Application for Planning Permission

Development: Change of use from dwelling house (use class C3) to 8-bed, 8-person house in multiple occupation (Sui Generis) to include a rear extension and loft conversion.

Location: 21 Longford Road Bognor Regis PO21 1AB

Drawing No: 260107 - 3.01 Rev: A

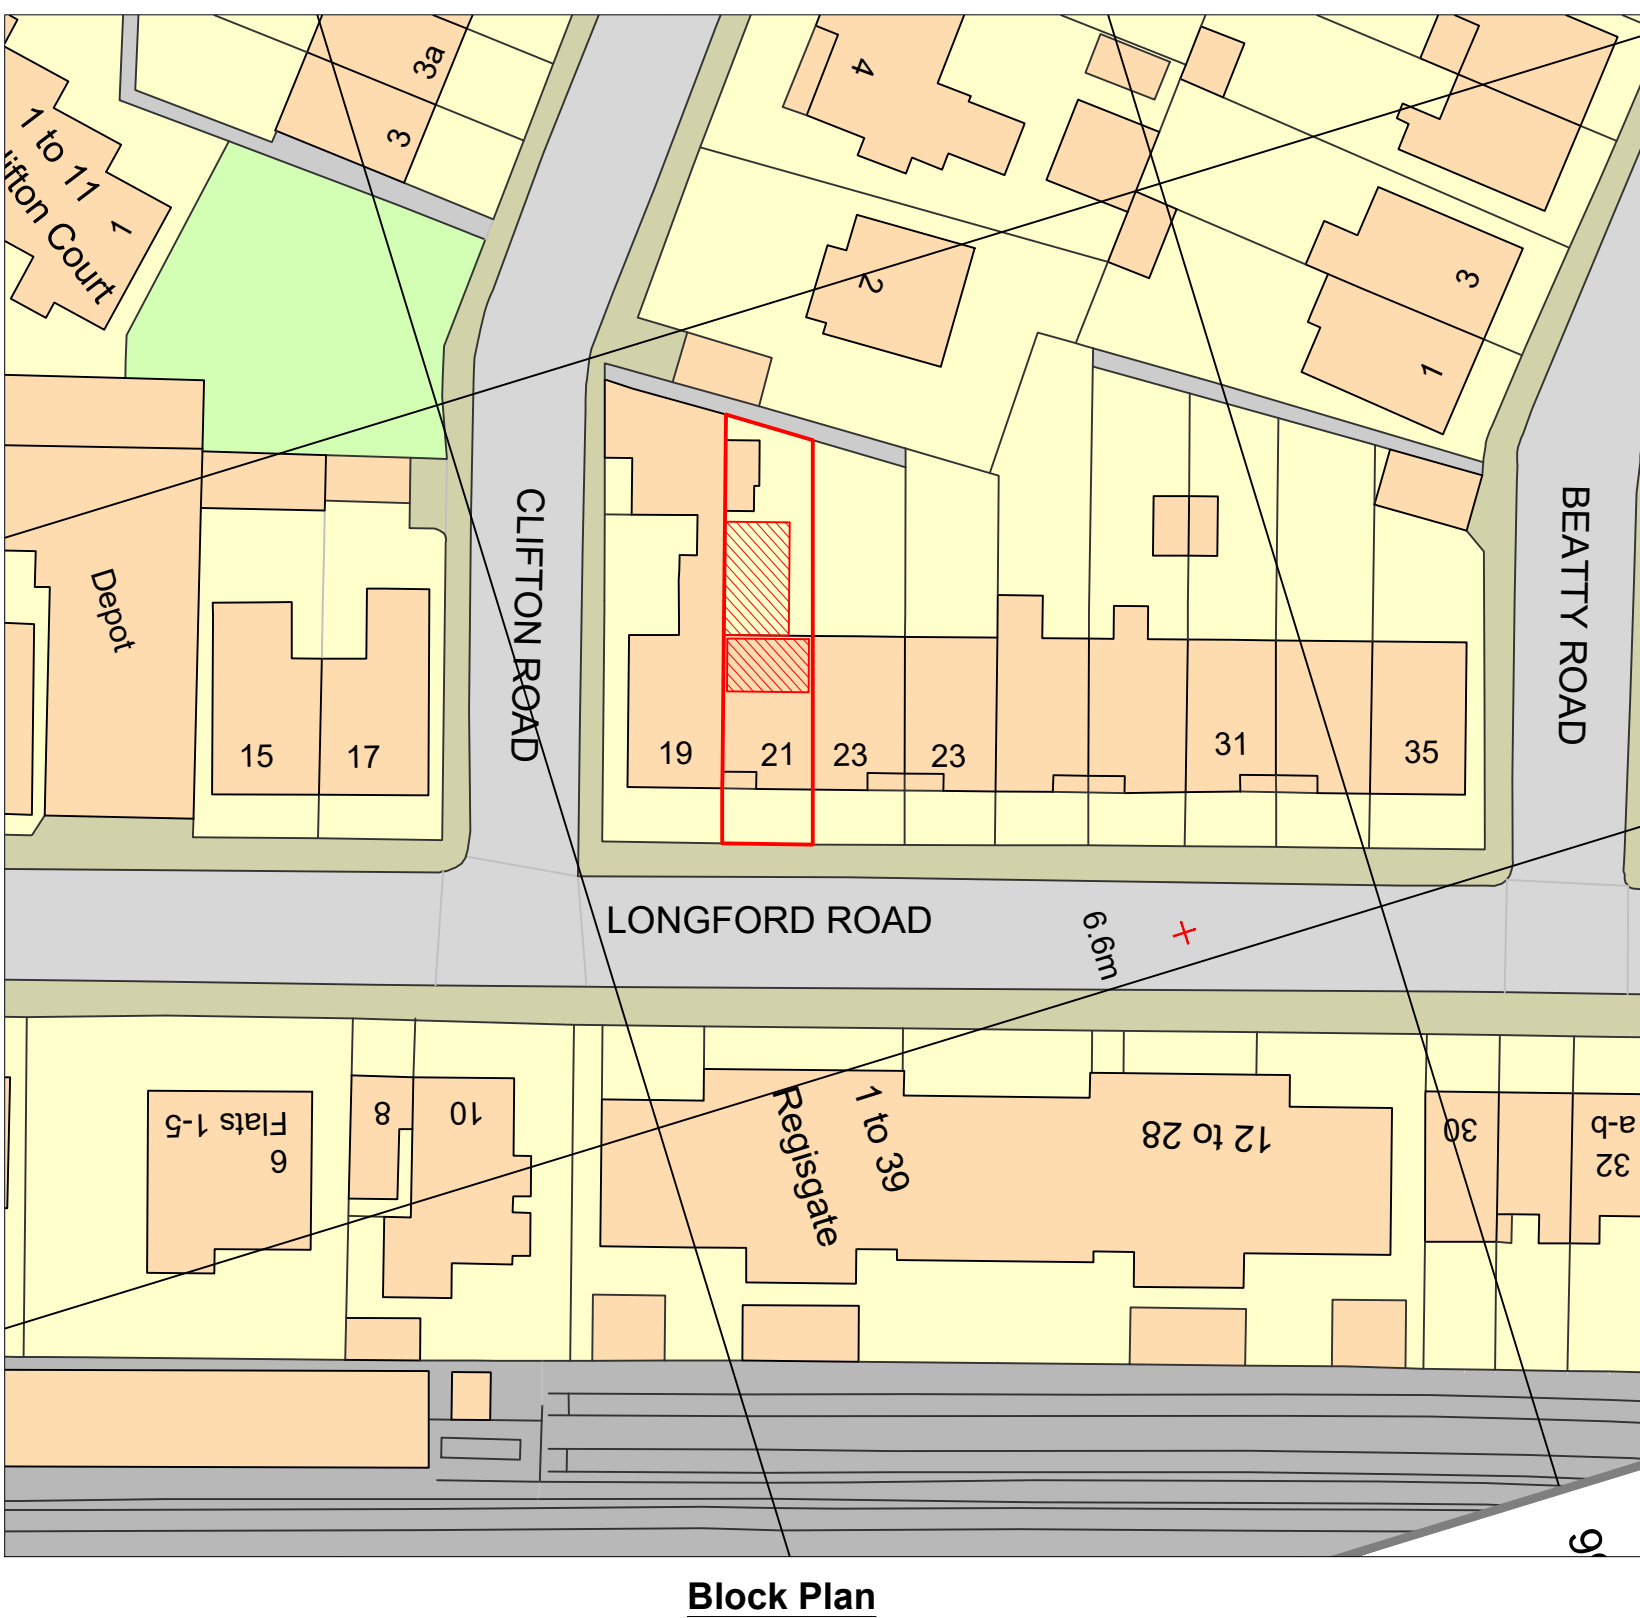
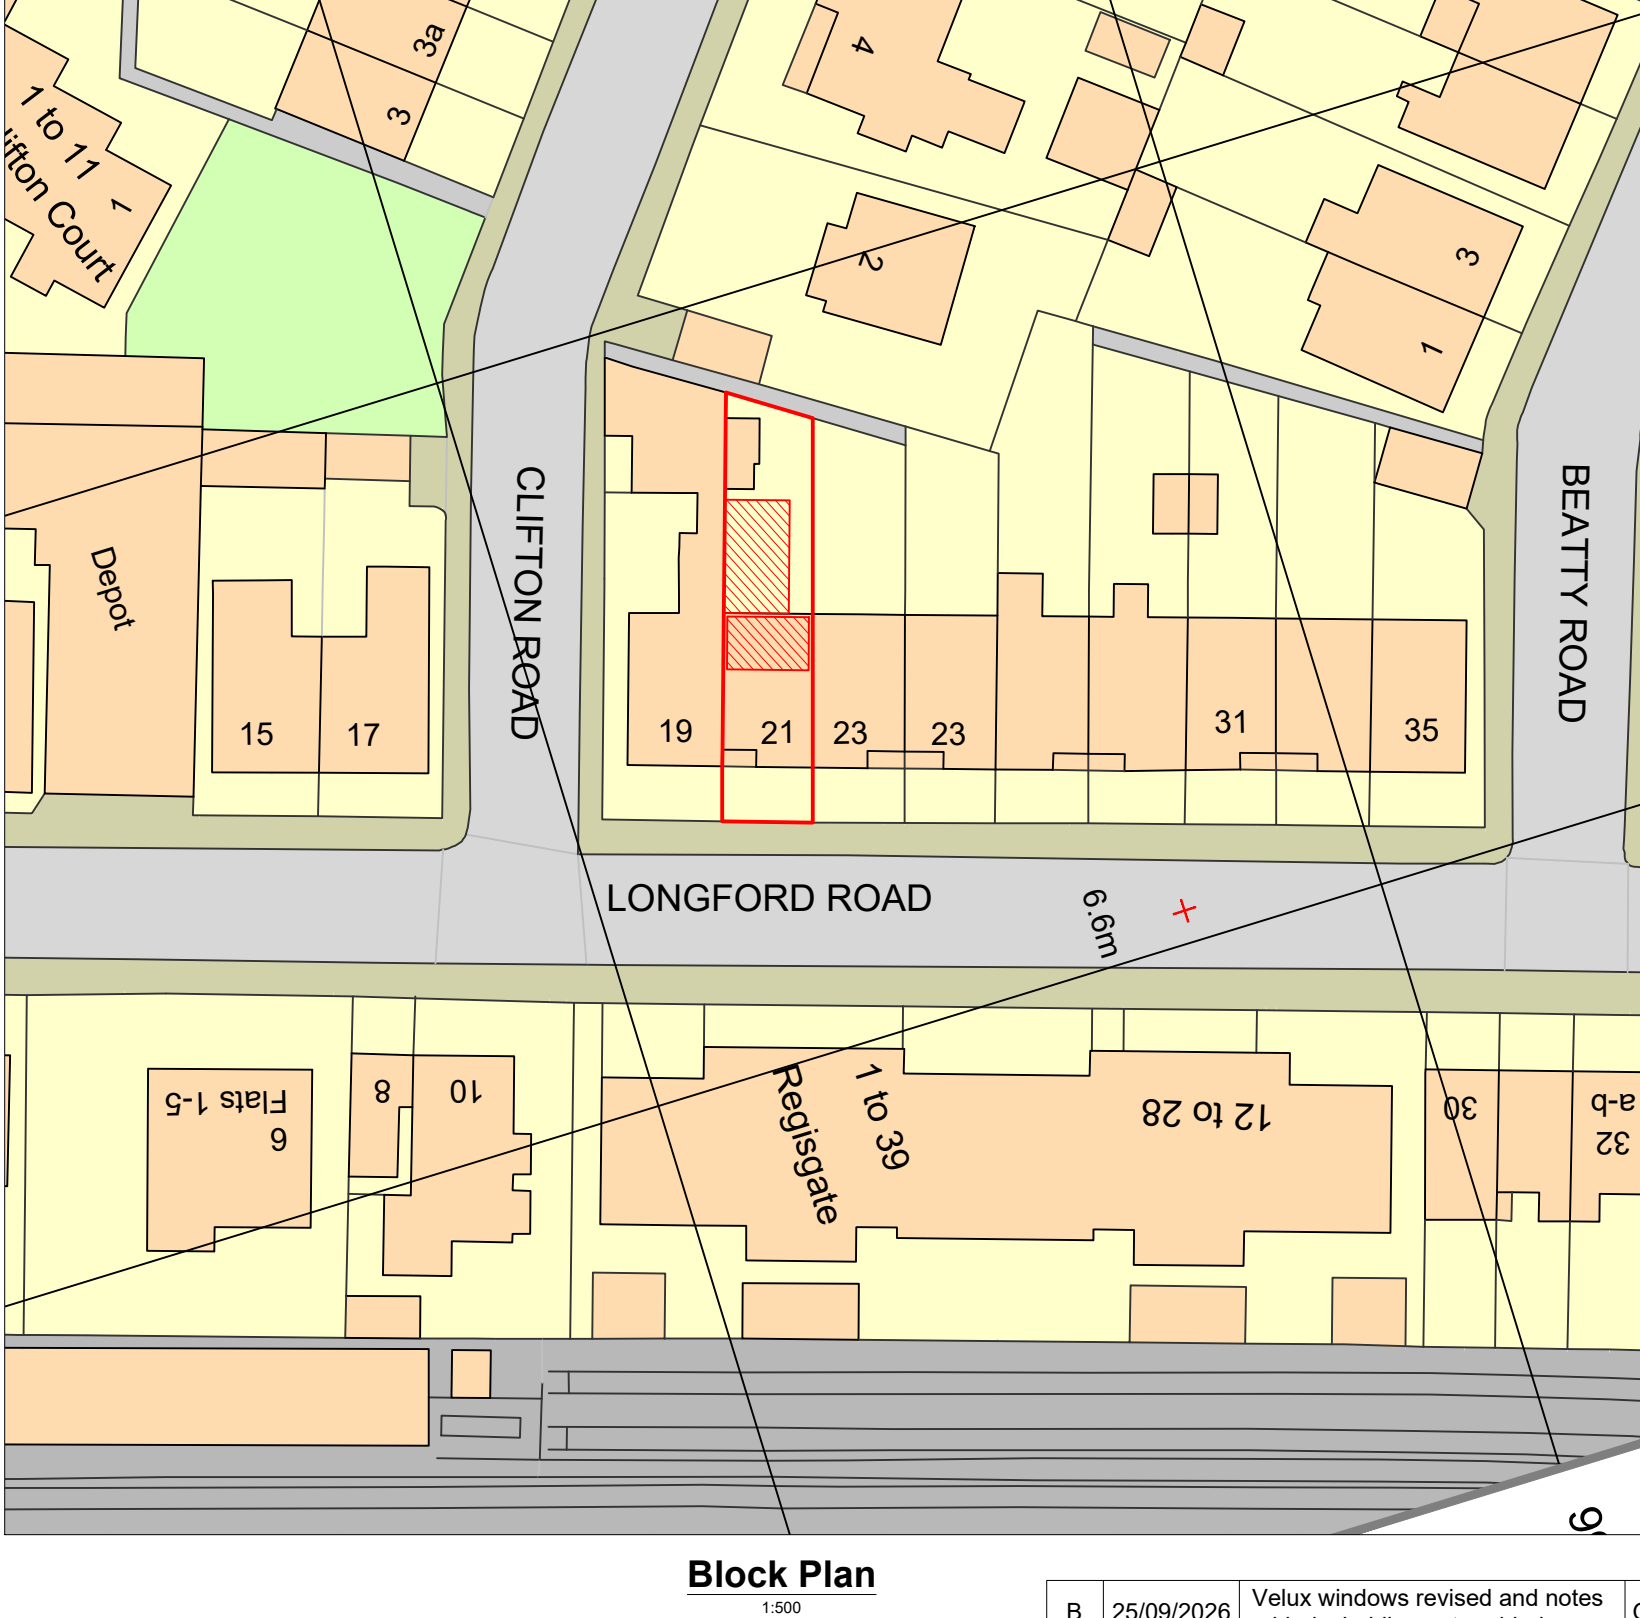
Block Plan

Your block plan has a label of 1:50 but is scaling correctly at 1:500, please amend the label.
